City of Albuquerque Stormwater Construction Site Inspection Report

ESC File No.	B18E031	Project Name:	Luxelocker
NPDES Id. No.	NMR1005MA	Location:	5601 San Diego Ave NE
6/24/2024	Owner	Contractor	
Operator	Albuquerque Storage Partners, LLC		
Contact name & title	Brian Francis		
e-mail	brian.francis@luxelocker.com		
Contact Phone #	928-412-1401		
COA Inspector	Chancellor English	Start/End Time:	2:30pm
Construction Phase:	verticals		
Type of Inspection:	<input checked="" type="checkbox"/> Regular	<input type="checkbox"/> Storm Event	<input type="checkbox"/> Post Storm Event >0.25" <input type="checkbox"/> 311/Complaint <input type="checkbox"/> Follow Up
Weather at time of inspection?	Clear	Temperature: ~	100
Estimated date of last storm 0.25" or greater	6/10/2024

4
C4
DROP INLET PROTECTION DETAIL
SCALE: NONE

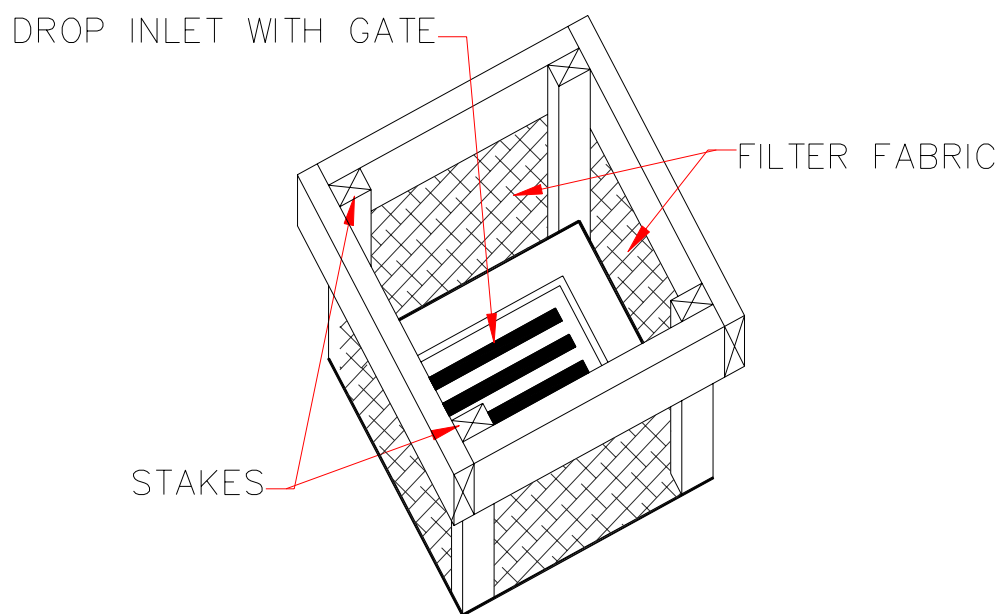
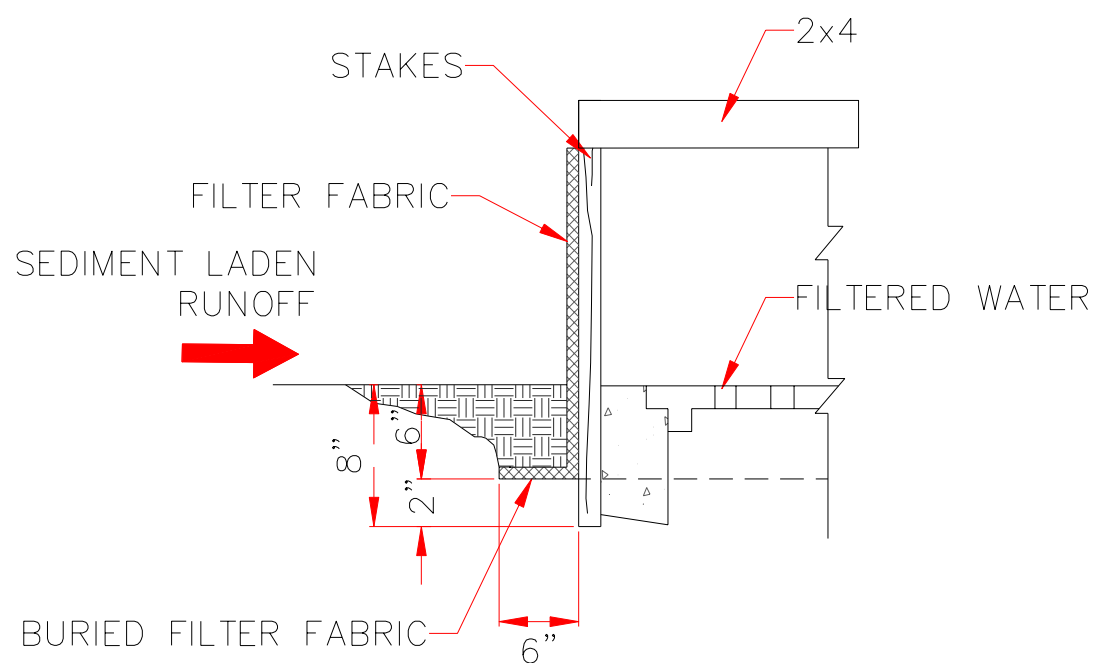
3	BMPs - Inlet protection measures are in need of maintenance in violation of CGP Part 2.1.4. Required mitigation: Ensure all stormwater controls are maintained and remain in effective operating condition during permit coverage and are protected from activities that would reduce their effectiveness per CGP Part 2.1.4.
